Edge Grove School, Aldenham, Hertfordshire

Former stable block: Addendum to the Heritage Statement

Edge Grove School has applied to Hertsmeire District Council for planning permission and listed building consent to extend and make internal alterations to a former stable block at the site. The block stands behind and to the right (north-east) of the grand house which forms the central element of the school complex and is a Grade II listed building (National Heritage List reference number 1130617 (<https://historicengland.org.uk/listing/the-list/list-entry/1103617>). The stable block is not listed in its own right, and is not mentioned in the list description for the house, but it is curtilage listed under the terms of the Planning (Listed Buildings and Conservation Areas) Act 1990, paragraph (5)(b). Bancroft Heritage Services prepared a Heritage Statement for the project in 2018 (final version dated March 2020). This describes the history and character of the stable block in detail. Hertsmeire District Council's Conservation Officers, however, required further information on various aspects of the building, mainly with regard to the proposed alterations to the interior of the stru

1 | Ground Floor Plan
1 : 100

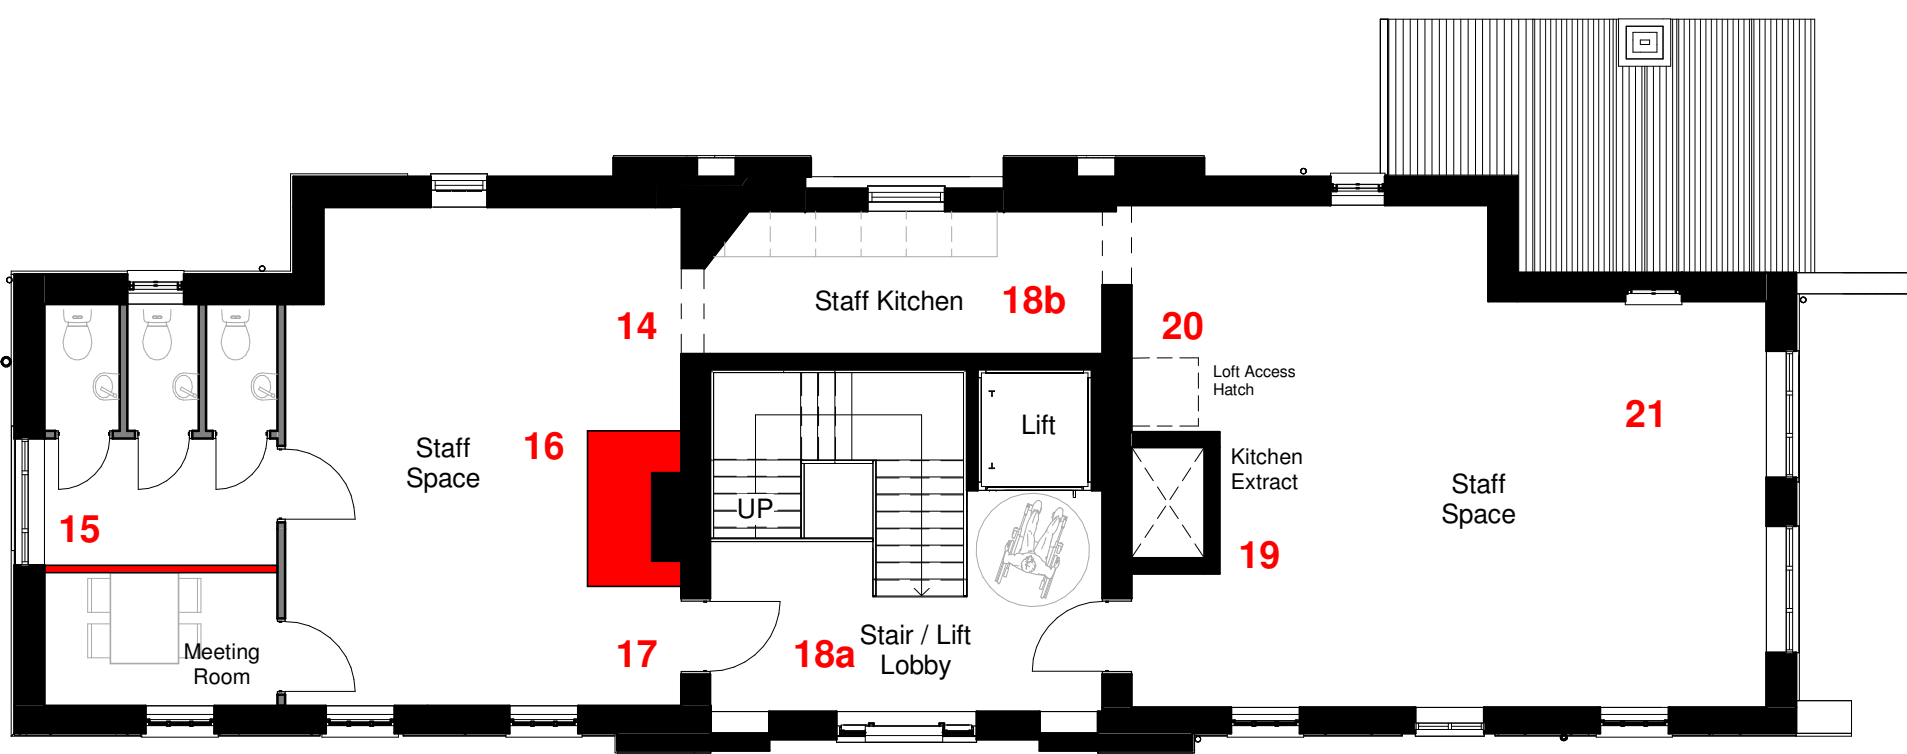
Item	Query	Response
Ground floor		
1	Proposed new door opening: <i>What age/value is this fabric? Was there a previous opening here to inform location of new opening?</i>	<p>The seemingly blank walls to the rear of the old stable block are original to it, and thus of 18th-century date. There is clear evidence of a former opening in this location, comprising vertical cracks in the rendered and painted wall face (now within the changing room) running down to floor level. Tap testing confirms that there is an audible change from the solid masonry to the sides with a 'hollowness' in the area between the cracks. The blank masonry is of limited significance/value despite its age (it is to the rear of the building, away from visibility from the house. The evidence for a former opening provides a good context for establishing the new one here, which will aid the utility of the original building as it relates to the proposed extension.</p>

<p>View of item/area 1 with clear cracking in the wall surface, extending into the plinth at the bottom on the left-hand side at least.</p>
2	Re-use of existing door: <i>What age/value is this fabric? Why is the new wall not on the alignment of the structure?</i>	<p>As with area 1, the blank wall was original 18th-century fabric. The door is late 20th-century and was cut through when the changing room was built. The house was listed in 1985; it is likely that listed building consent would not have been required when the extension was built and the door was knocked through. The angled wall just inside the door is unusual and, in my</p>

Item	Query	Response
5	Iron column currently encapsulated in a modern stud partition: <i>How will iron column be retained?</i>	LSH to review how iron column can be retained – it should be feasible to do so.
		 <p data-bbox="815 1104 1386 1272">Late 19th-century cast-iron column now within modern stud partition (arrowed from left). Note evidence for the former position of a matching column on the ceiling beam, arrowed from the top.</p>
6	Re-arranged interior/offices. <i>Appears all walls are to be lined?</i>	This is a matter for LSH.
7	Location of new staircase and lift. <i>What age/value is the ceiling fabric?</i>	The ceiling is modern and of no heritage value. It is suspended off the floor above, which is late 19 th /early 20 th century and also of low heritage value (see item 18).
		 <p data-bbox="815 1933 1386 1986">Modern suspended ceiling in classroom SB5. Note angled wall (item 2) to the right.</p>

Item	Query	Response
8	New door. <i>What age/value is this fabric? Was there a previous opening here to inform location of new opening?</i>	The masonry here appears to be original 18 th -century fabric. It is plain and featureless, of low heritage value because of this. All agreed that a door would be an acceptable intervention given the advantages of access and circulation it provides.
		 <p data-bbox="815 887 1391 943">Blank brick masonry visible in the south-eastern corner of classroom SB5.</p>
9	New kitchen. <i>What interventions are needed to make this a kitchen? Lining of walls? Extractor fans? Bins? Storage?</i>	This is a matter for LSH.
9a	Store cupboard wall. <i>What is the age and significance of boarding? Check ceiling structure above, architect and client to consider retention of boarded partition.</i>	Boarding appears to be late 19 th -early 20 th century, resting on a sole plate set within the interior of the former stable. Probably put in to make a corridor across the back of the stables to the small extension (contemporary) at the north-east corner of the building. The top part of the partition within the cupboard is modern chipboard or similar, continuing above the false ceiling. There is also a modern opening (but blocked with board) at the east end of the wall. Opening up shows that this extends above the false ceiling up to a modern timber with the positions of former fixtures (hooks?) evident, and stencilled numbers between them (67-70 at least). This is at high level, immediately below what appears to be a rendered ceiling. The opening up confirms that the upper ceiling is of tongue-and-groove boards immediately to the west of this, entirely modern. The render must have been applied to this locally because it was within the corridor and rooms in use at the time. All the other partitions in this area are modern as well. The boarding has some value but will be vulnerable if retained here - may be better re-used elsewhere in the

Item	Query	Response
12	New door. <i>What age/value is this fabric? Was there a previous opening here to inform location of new opening?</i>	<p>The seemingly blank walls to the rear of the old stable block are original to it, and thus of 18th-century date. There is clear evidence of a former opening in this location internally and externally, comprising vertical cracks in the rendered and painted wall face on the inside and very obvious disruption in the roughcast render outside. As with locations 1 and 3 it is clear that there was an opening in this location historically. The blank masonry is of limited significance/value despite its age (it is to the rear of the building, away from visibility from the house). The evidence for a former opening provides a good context for establishing the new one here, which will aid the utility of the original building as it relates to the proposed extension.</p>

<p>Vertical joint in the external roughcast showing where an opening once existed in this wall.</p>
13	Removed door to store cupboard, and door to adjacent classroom. <i>What age/value is this fabric? What's the justification for the loss of fabric and divergence from plan form?</i>	<p>The west end wall of the store is an obviously modern stud partition, with a door of the same age. No heritage value. The wall immediately to the south is original, however, and retains a lintel set high in the masonry. This is of medium heritage value. This fabric to be retained.</p>

1 | Ground Floor Plan  
1 : 100

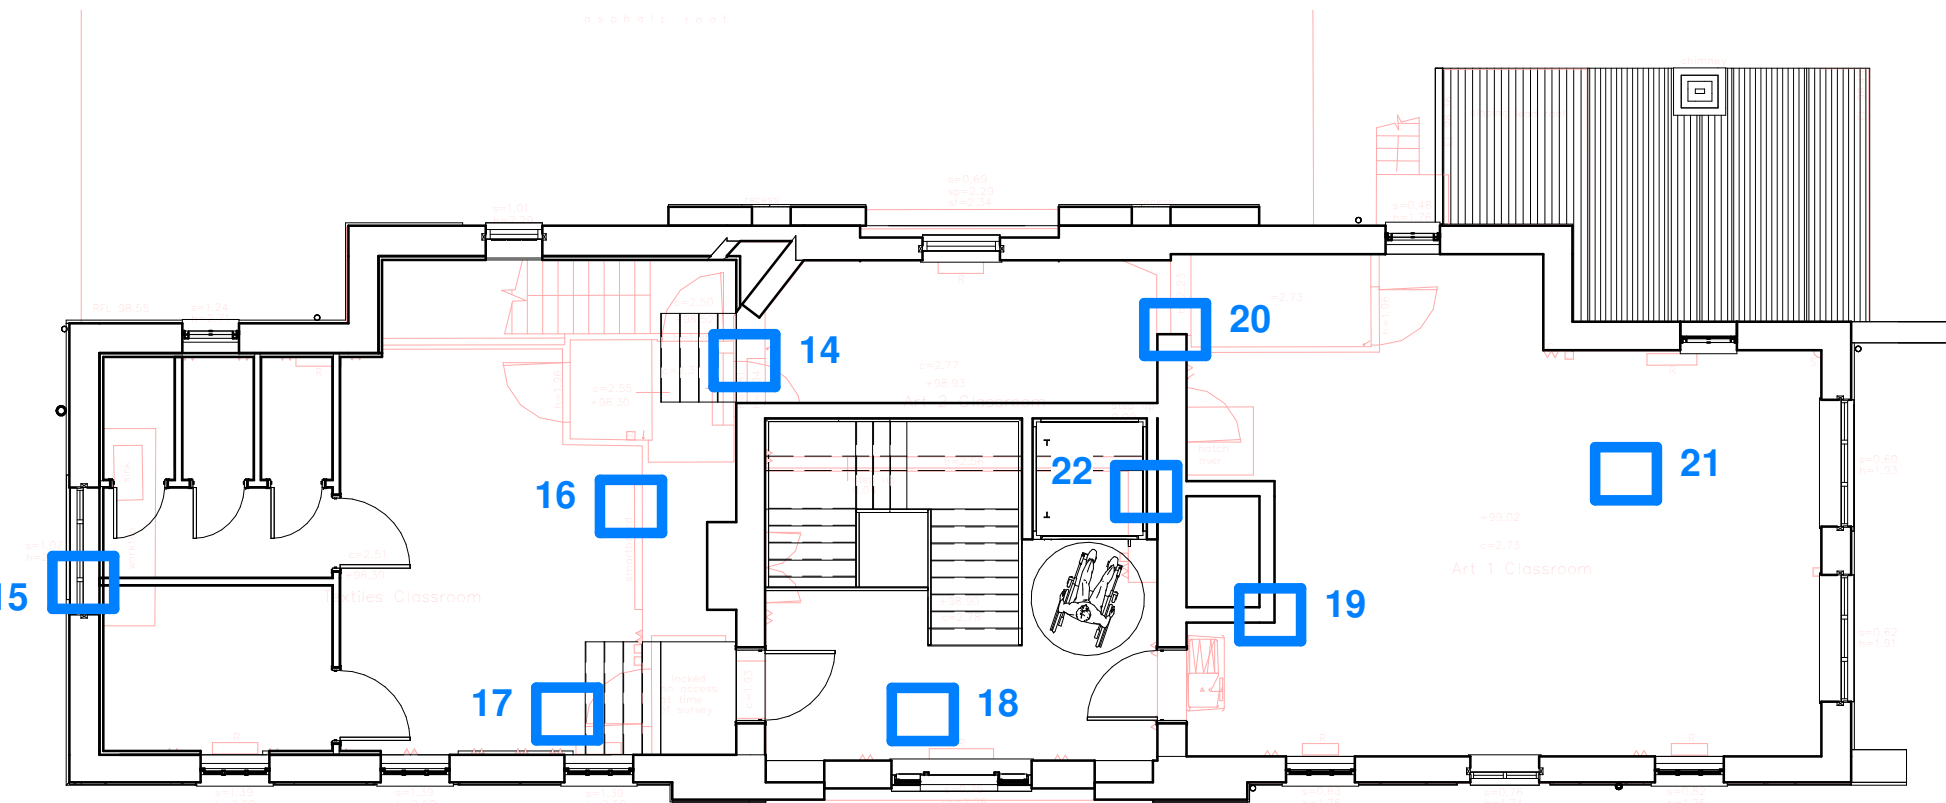
Item	Query	Response
		 <p data-bbox="815 797 1375 898">Lintel of existing door (locked shut from the other side) in classroom SB5. The partition and door to the left are modern.</p>
First floor		
14	Alteration to doorway, new steps. <i>What age/value is this fabric? How will this relocated stair impact upon fabric and ground floor?</i>	The foyer/doorway into this classroom are modern and of no heritage value. The steps (not a stair) are confined to the first floor and has no impact on the ground floor below. It may be possible to dispense with the steps if the floor and ceiling heights in the classroom can be raised to provide level access through to the central bay and the new staircase there.
15	New partition. <i>Plans appear to over-board this wall and to subdivide window.</i>	LSH to consider amending partition to avoid window.
16	Cutting back masonry – continuation of chimney stack from ground floor? <i>Plans show significant alteration to this area without detail or justification.</i>	GK advised there is a significant amount of modern surface treatment and some parts of the wall are probably modern, but the stack may survive within this. LSH to consider removal of modern elements whilst retaining bread oven stack.

Item	Query	Response
	lift in the central bay. LSH and School to review.	
17	New steps up to re-used existing door. <i>How will new stair impact upon fabric both upon ground and first floor? Was there a previous opening in this location?</i>	These are steps, not a stair - no impact on ground floor. Steps may not be necessary (see comments immediately above). Door is clearly historic – visible from the central bay.
18	Location of new staircase and lift. <i>What age/value is this floor?</i>	Narrow machine-sawn floorboards, late 19 th or early 20 th century date. Low heritage value. This part of the stable block would have been the coach house, probably open to the roof with at most a corridor at first-floor level to link the two outer bays (though even these might not have been floored).
		 <p data-bbox="815 1496 1391 1559">Narrow, machine-sawn floorboards on the first floor, central bay.</p>
19	Extractor location. <i>What age/value is this fabric? How will extractor impact?</i>	There is no fabric within the classroom in this location at the moment. The roof structure above was inspected during the visit and is of standard truss form, of mid to late 19 th -century machine-sawn timberwork. There is clear photographic evidence for a chimney on the ridge line in this location during the mid-20 th -century at least, with a matching one to the west. The latter appears to be over the stack rising from the existing bread oven on the ground floor (see image below). It is not known when the chimneys above roof level were removed – clearly neither chimney was

20	Alterations to doorway. <i>What age/value is this fabric?</i>	Doorway and door – the fabric above and to the right is modern studwork, of no heritage value; to the left it is brick masonry.

21	General comment. <i>Need to fully explore fabric – even if covered by fittings such as whiteboard.</i>	An appropriate programme of opening up was agreed during the meeting and has been done subsequently.
22	New Item: <i>Removal of existing chimney stack.</i>	I am doubtful that this is a stack – there is no trace of an equivalent on the ground floor below where the masonry is exposed at upper wall level and there is no scar of a former or removed feature. That said, this thickening of the wall is a clear feature on the first floor and
